Current Zoning: R-5 AIR (single family residential, Airport Noise Overlay), B-2 AIR (general business, Airport Noise Overlay)
Proposed Zoning: UR-2(CD) AIR (urban residential, conditional, Airport Noise Overlay)

Approximately 7.7 acres located on Tennyson Drive near Interstate 85.

The petition proposes to allow 38 single family attached residential dwelling units on a vacant site in the Enderly Park neighborhood.

# RZ-3

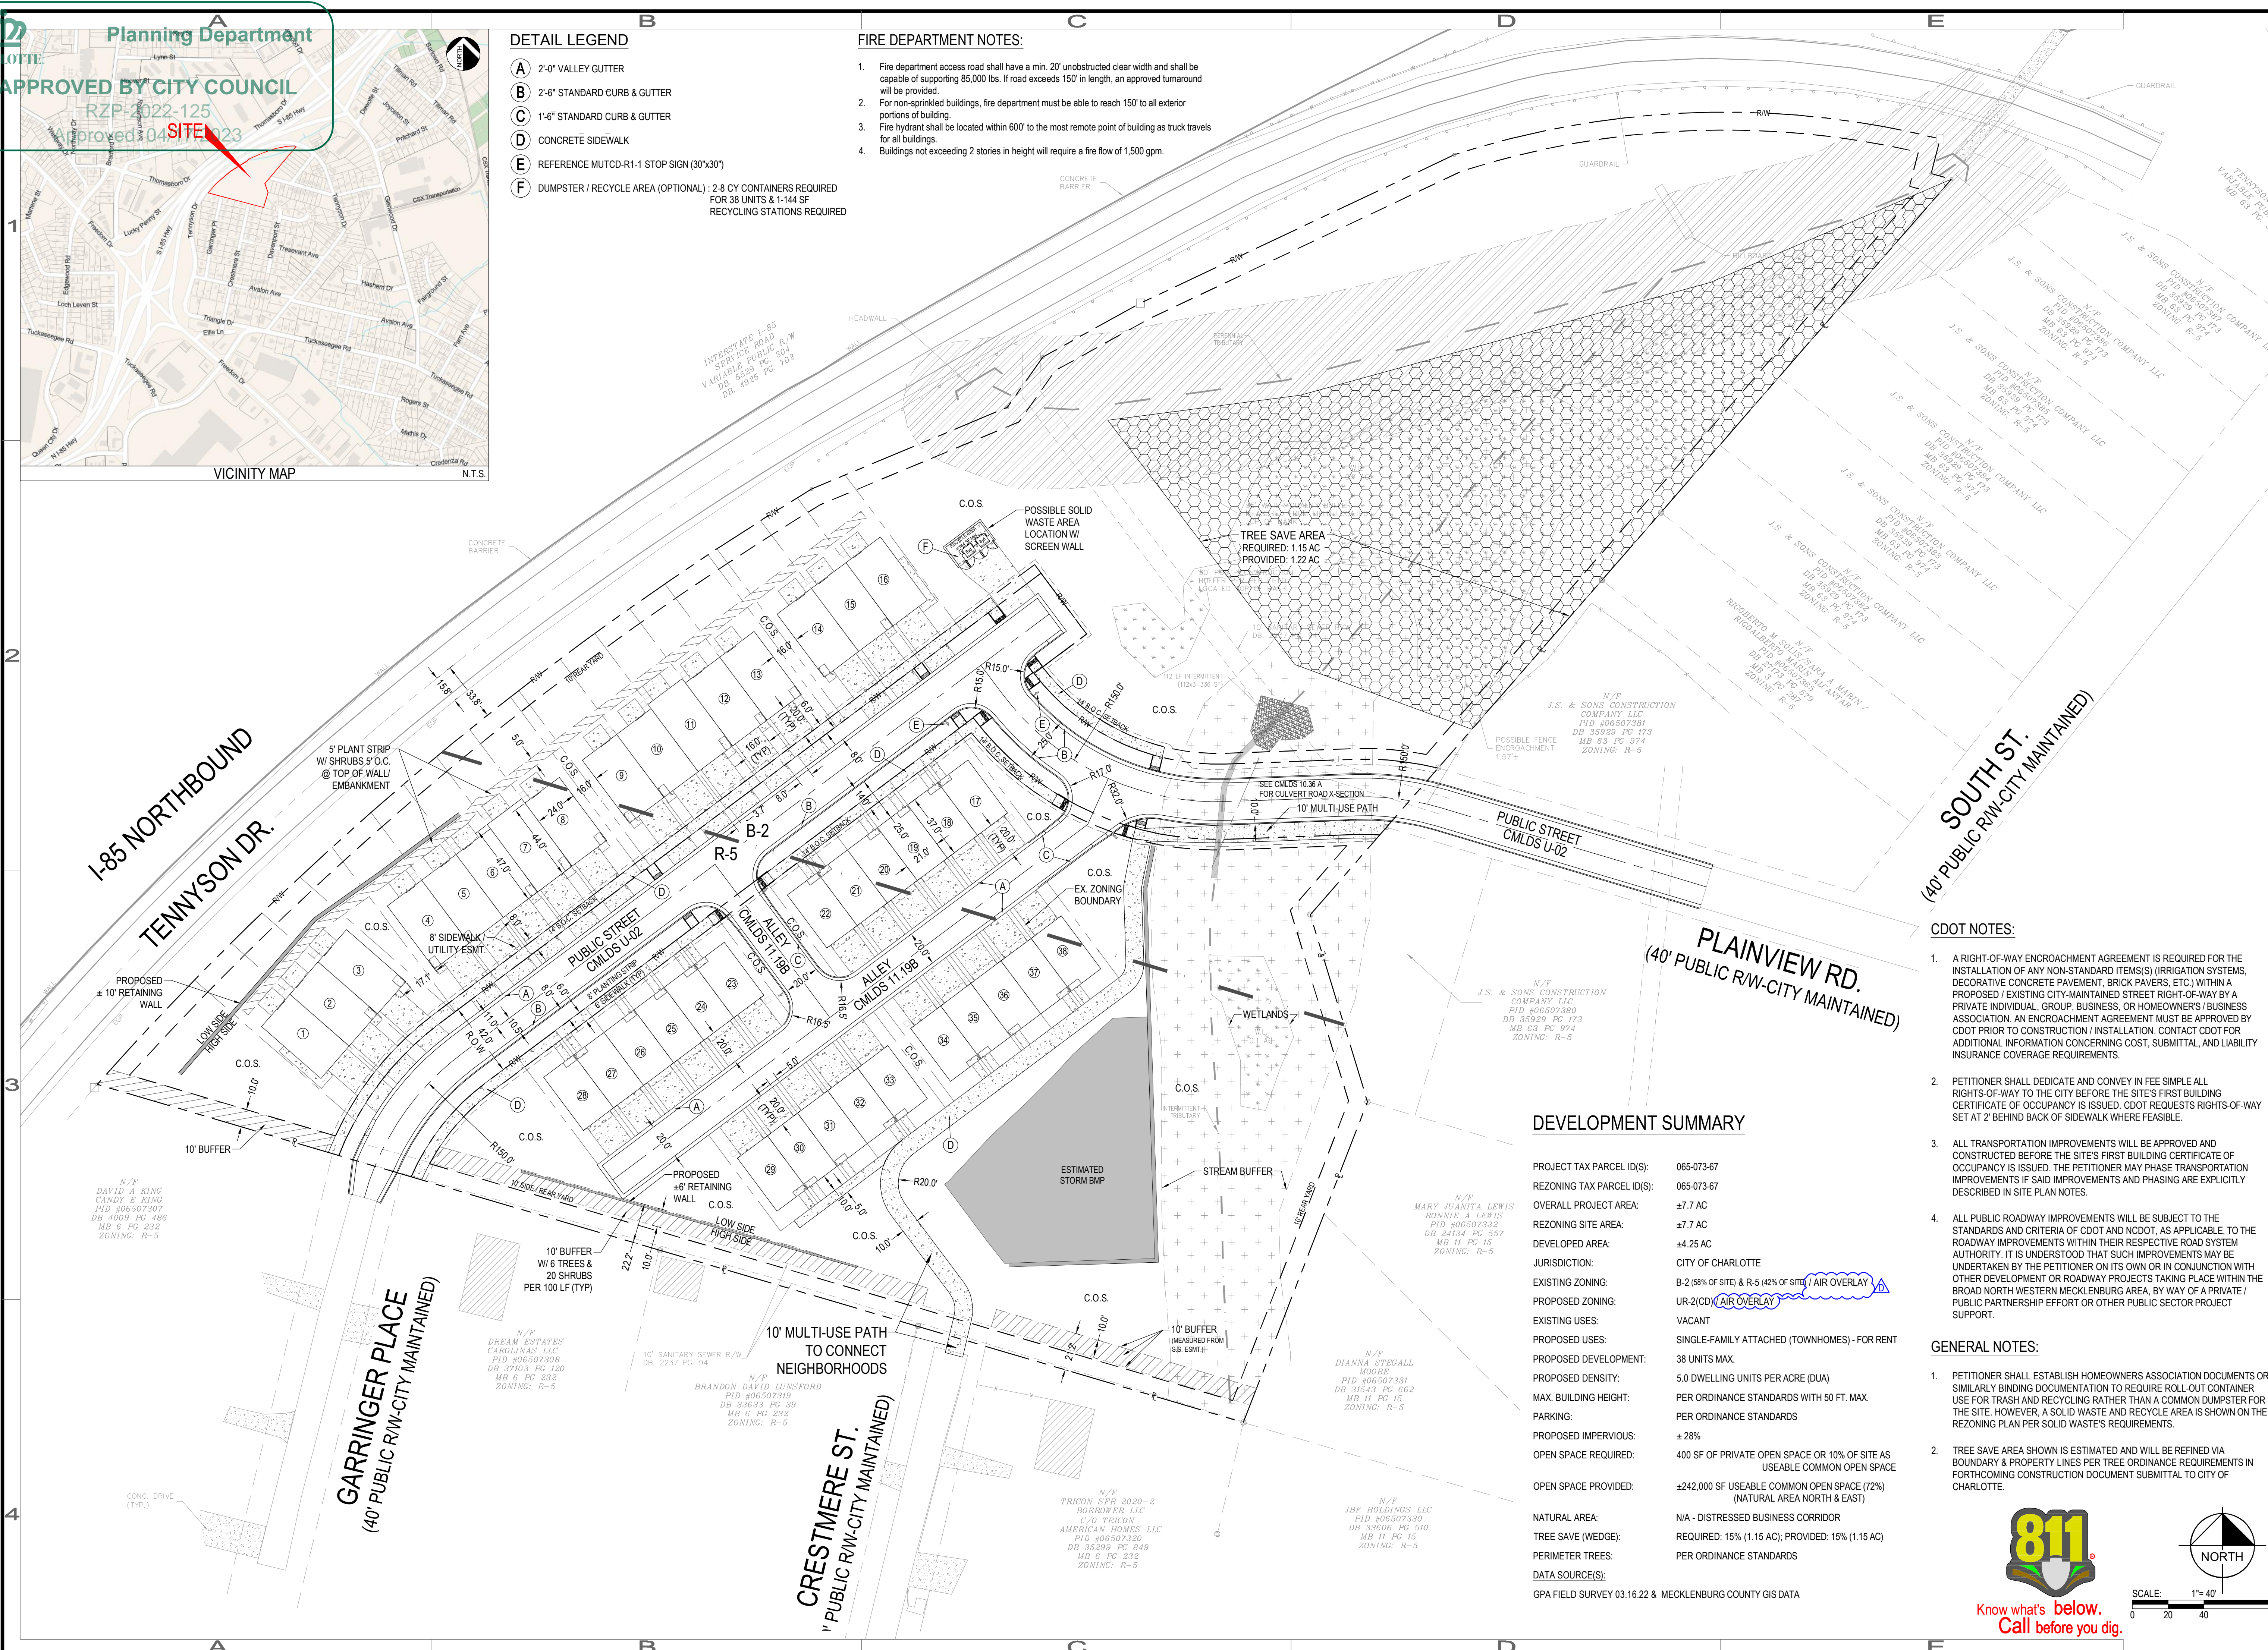
1. ~~Add "AIR" to both the existing and proposed zoning on site plan. This site is within the Airport Noise Overlay, abbreviated as "AIR".~~ **ADDRESSED**

2. ~~Revise roadway design to remove 90 degree turn and satisfy CDOT standards for public roadway geometry.~~ **ADDRESSED**
